TfNSW Reference: SYD18/01322/63

Departments Reference: SSD 9522 MOD 3

AMMENDED APPLICATION - SECTION 4.55 (2) MODIFICATION TO PROPOSED WAREHOUSE & LOGISTICS HUB - 657-769 MAMRE ROAD - KEMPS CREEK - SSD 9522-MOD 3

DRAWING TITLE	TURNING PATHS PLAN-SHEET 3
	STAGE 2 INTERSECTION
	MOD 3
DRAWING No.	C013362 02-SK3-06

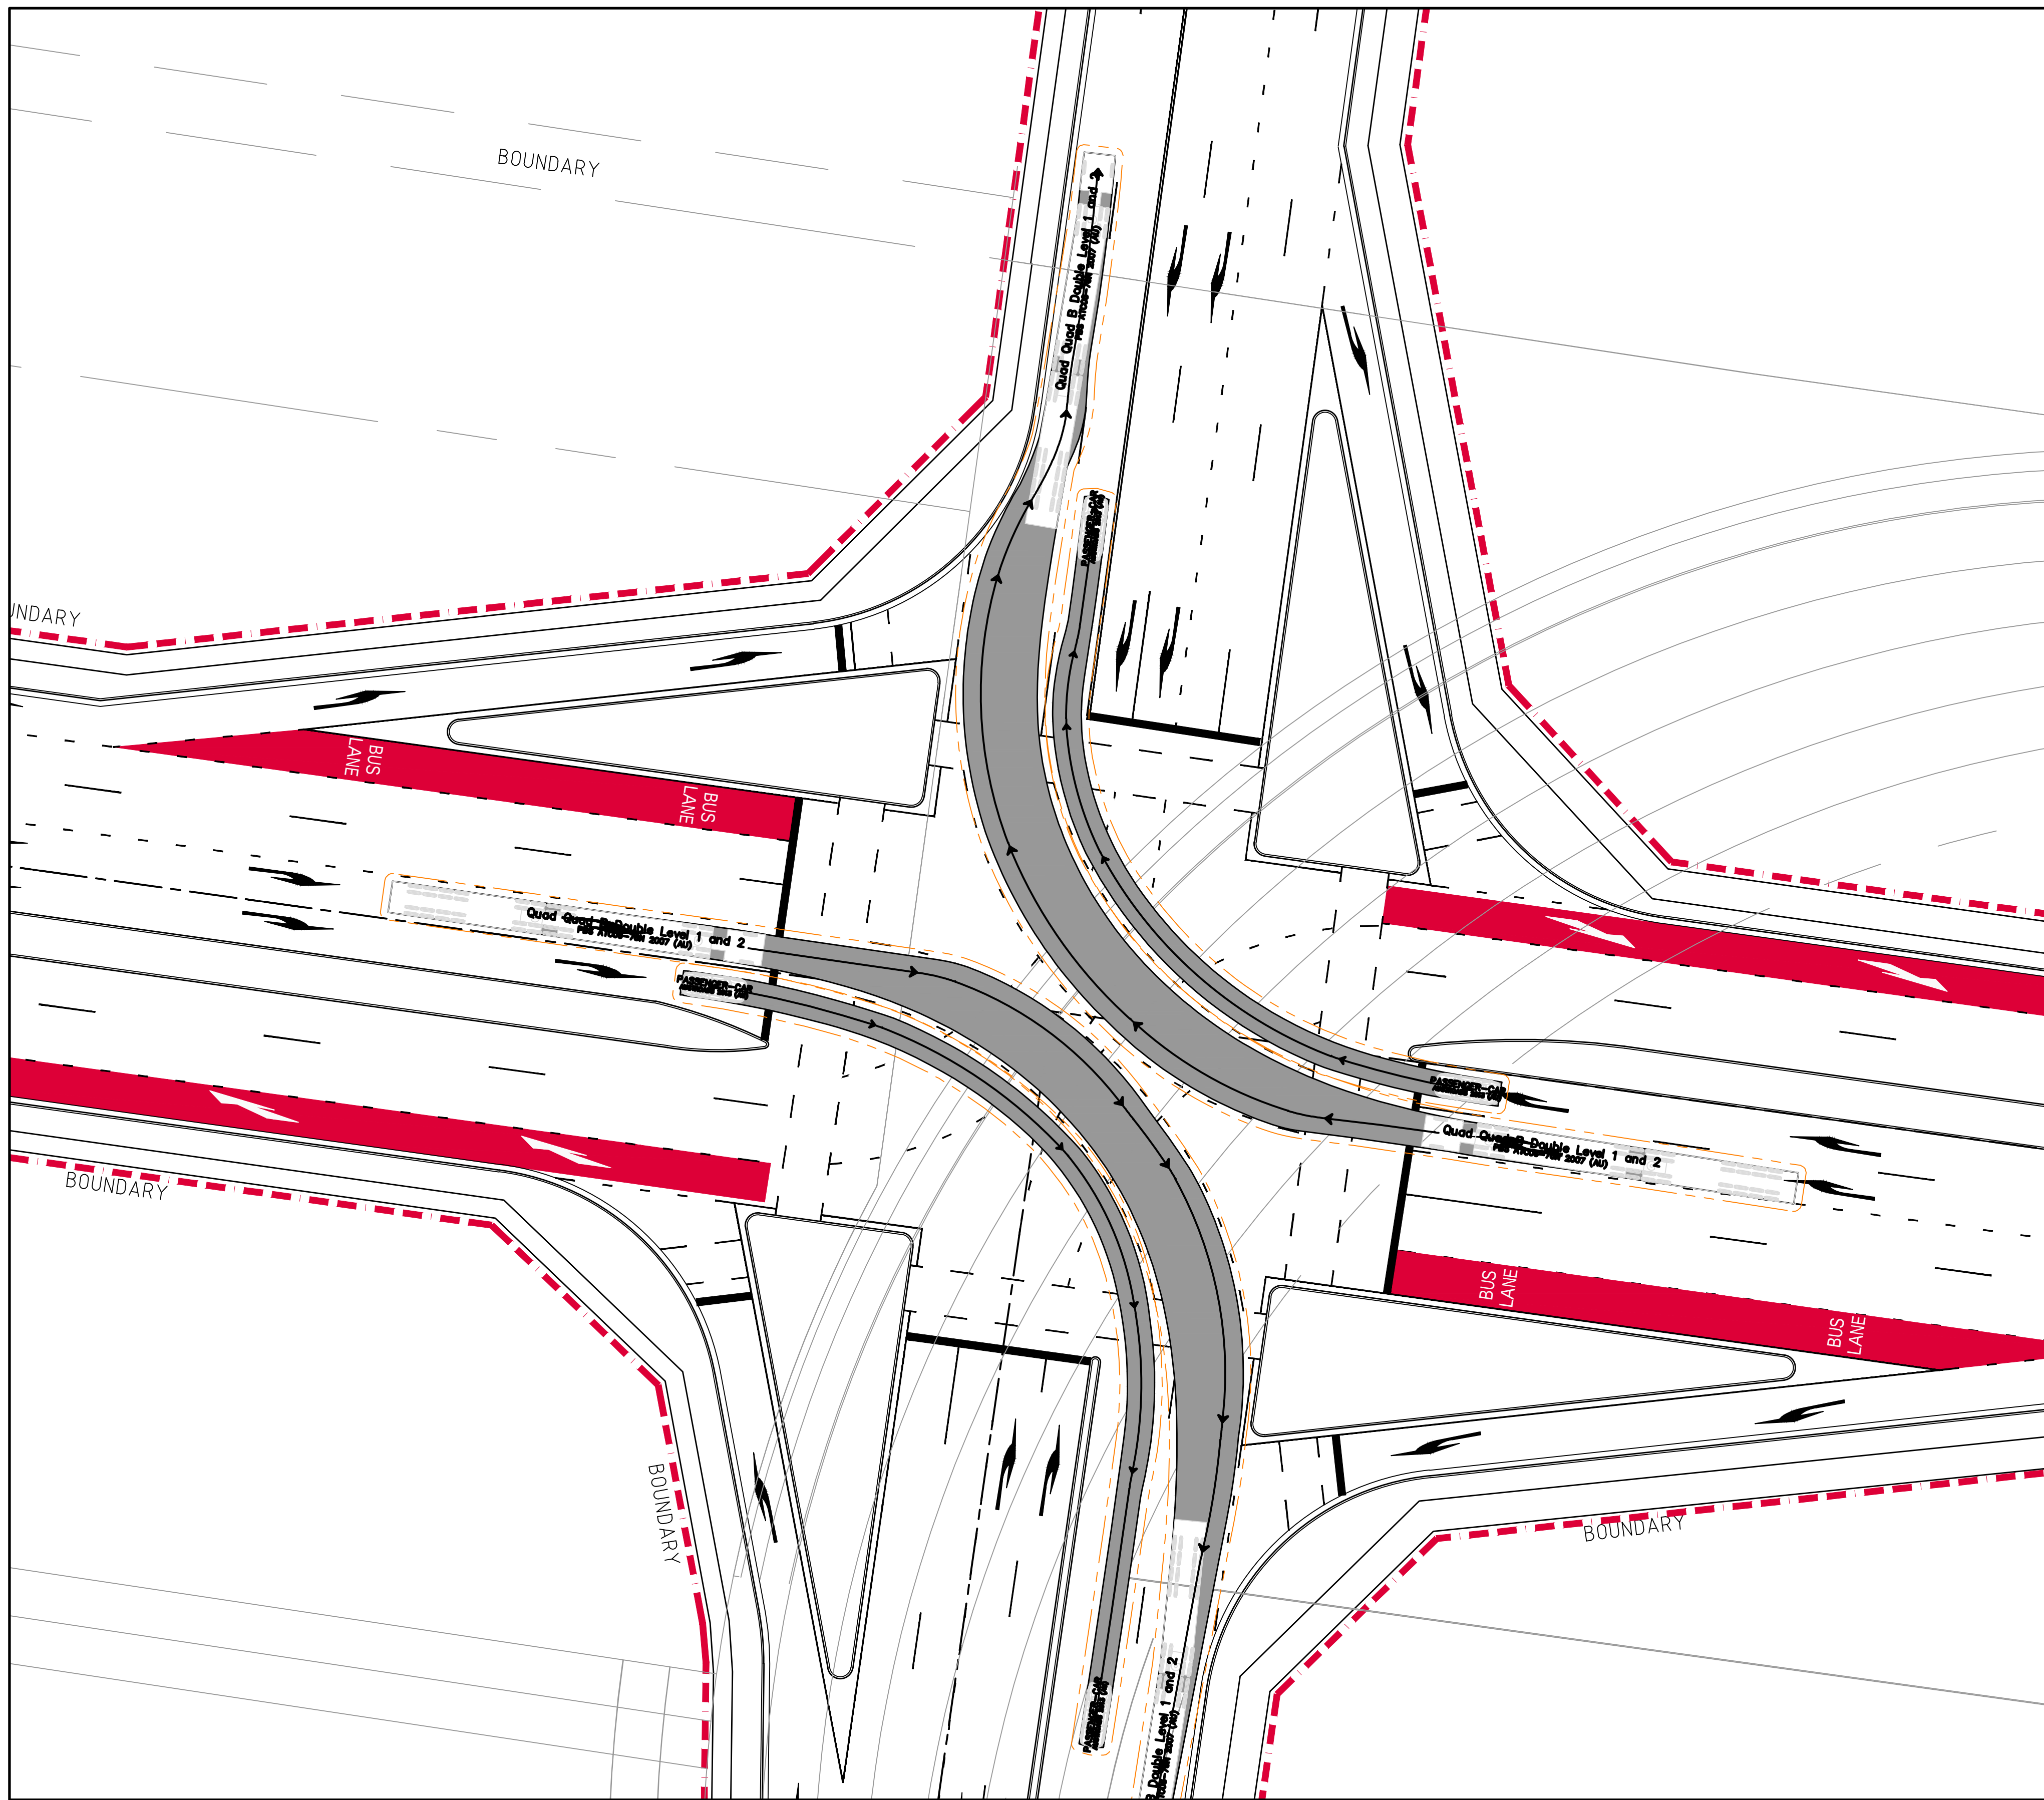
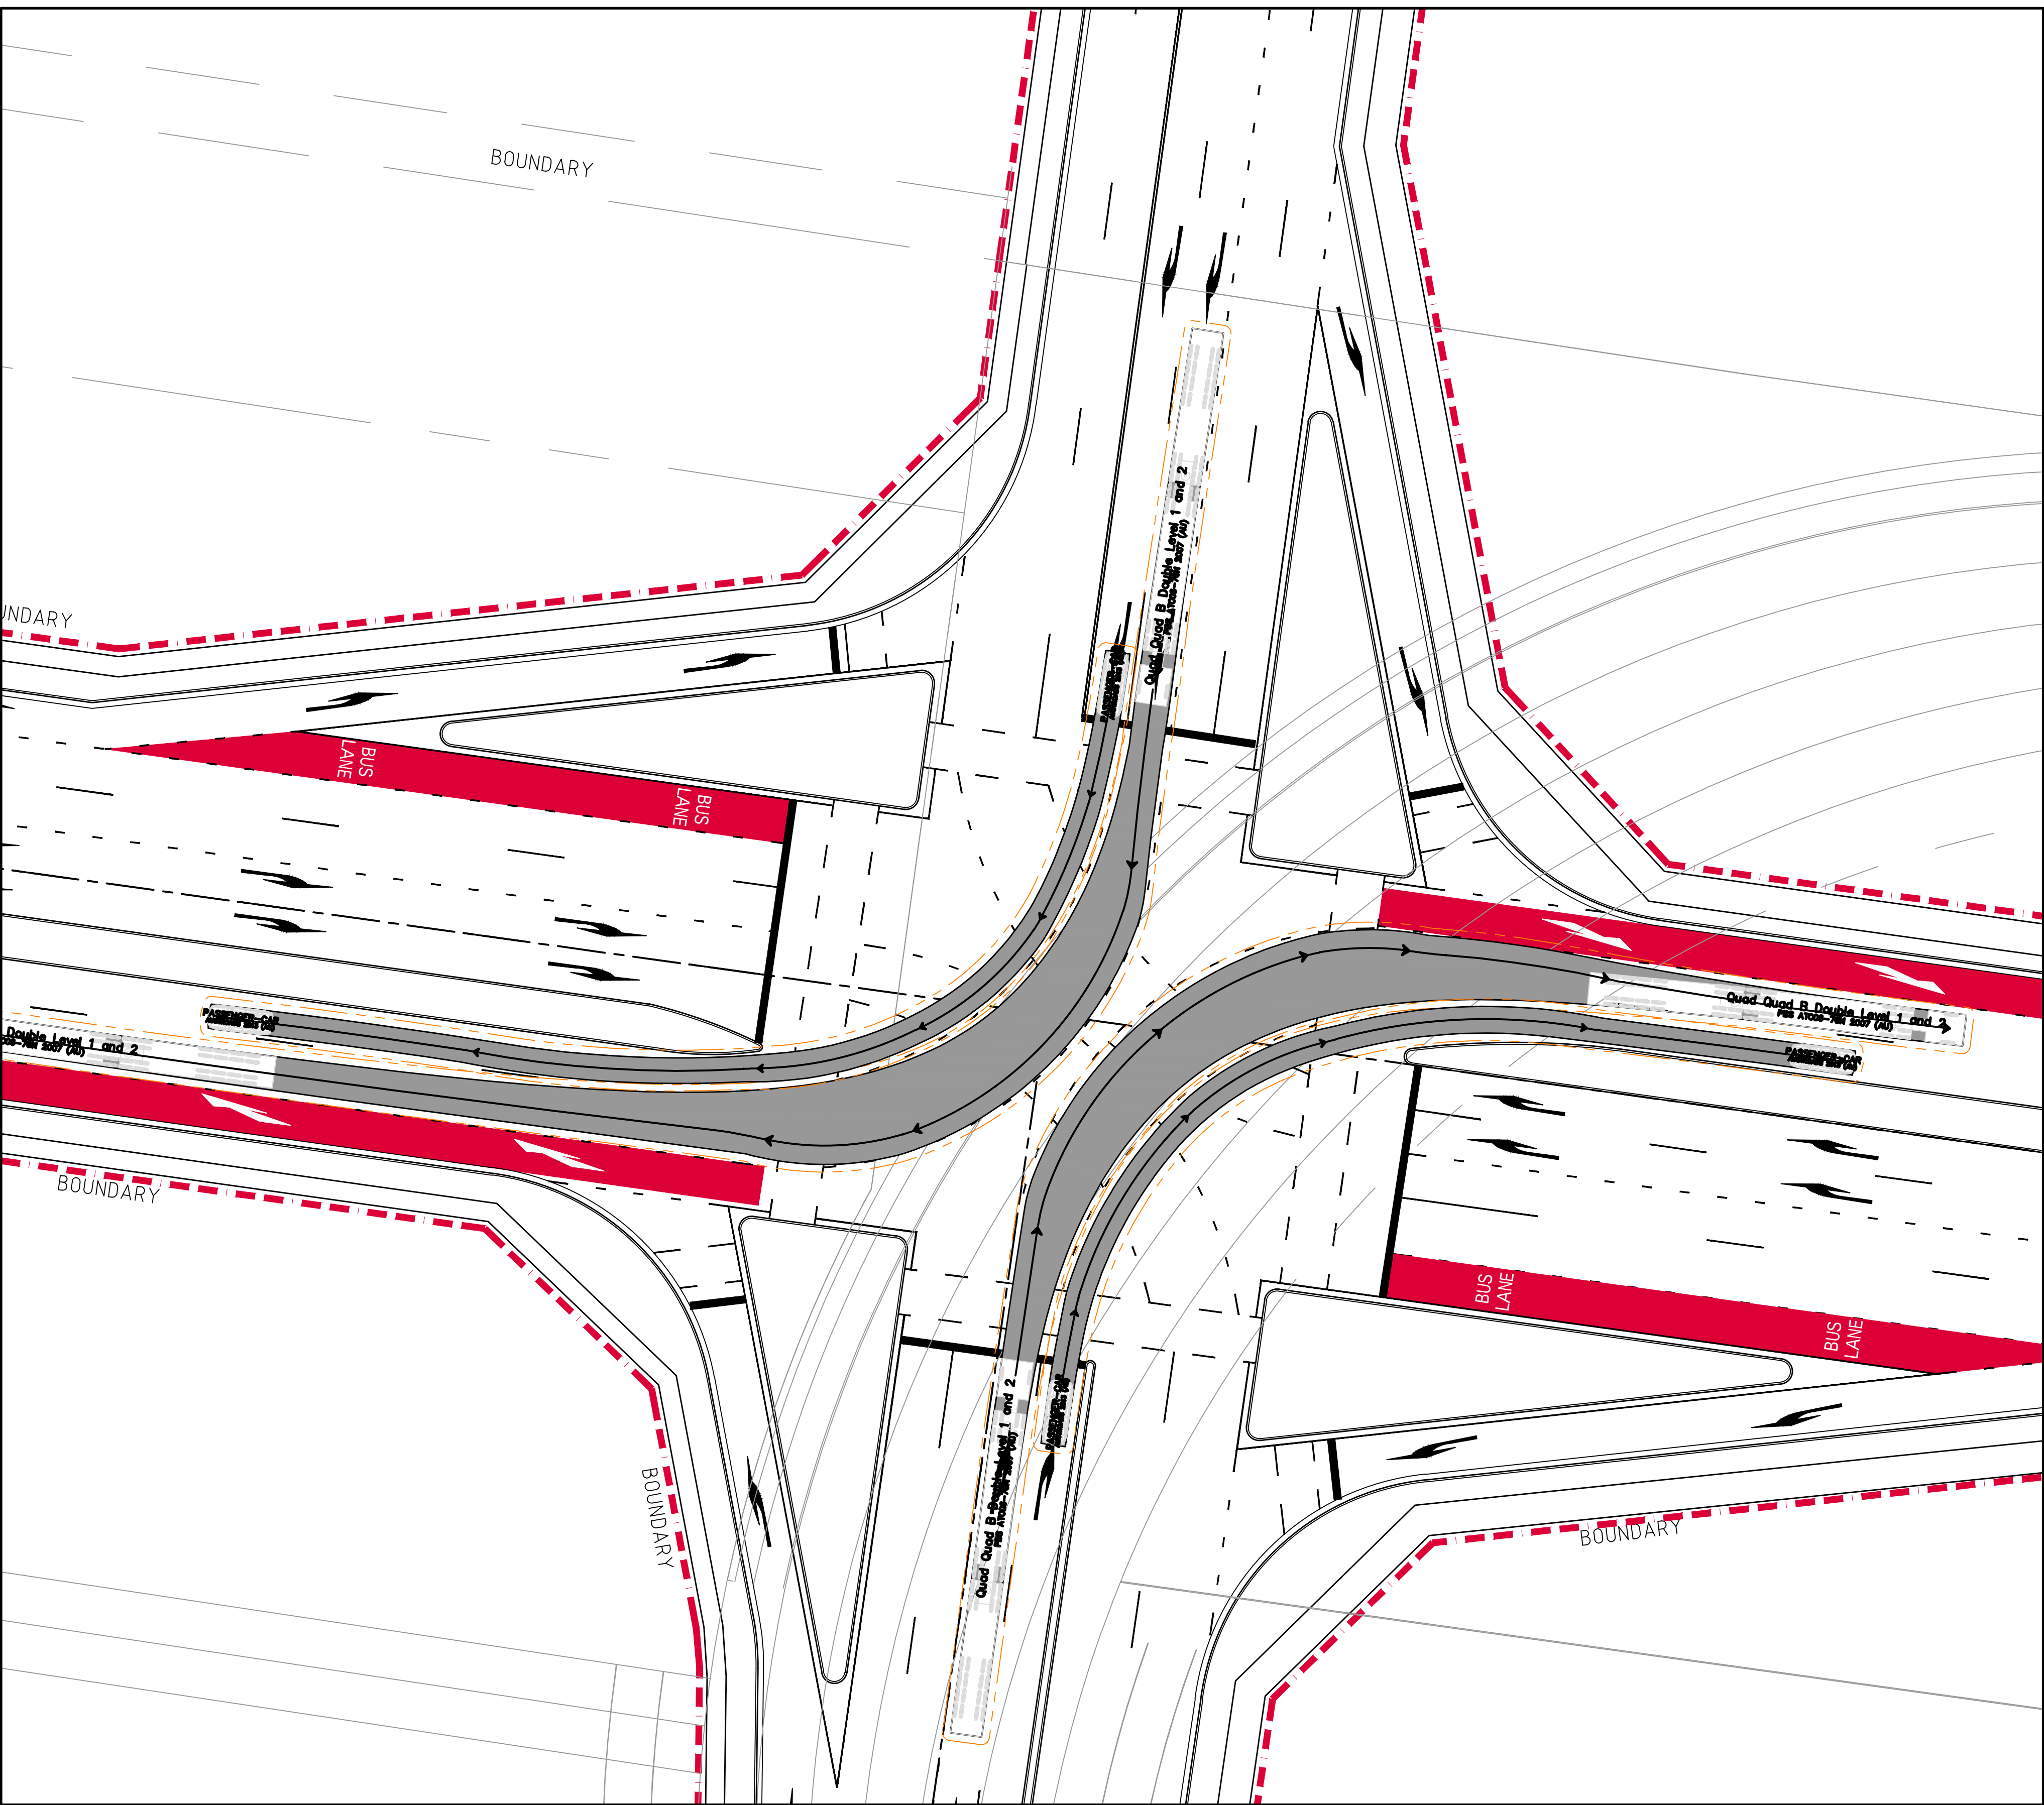
The proposed design for the future Southern Link Road ultimate intersection design is not supported by TfNSW. The location is a greenfield site and therefore the design should not be compromised by the surrounding proposed lot configuration.

The current plan has design elements that are non-conforming to current approved standards which would not be able to be designed out in further design stages. These design elements include but are not limited to, inadequate sight distance on approach to the intersection; below standard horizontal geometry for the northbound through movement; angled pedestrian crossings; high angled and tight swept paths etc. This is primarily due to the alignment of the northern leg of the intersection (Bakers Lane) which should be as close to 90 degrees with the Southern Link Road as possible. In addition TfNSW reiterates that only a double diamond would be supported for this location and any designs will need to ensure that a double diamond can be achieved.

Southern Link Road and Access Road 1 (south) ultimate intersection design will be designed and constructed as a T-intersection and access to Lots 1-4 will access Southern Link Road directly and be restricted to left in left out only from access road (north).
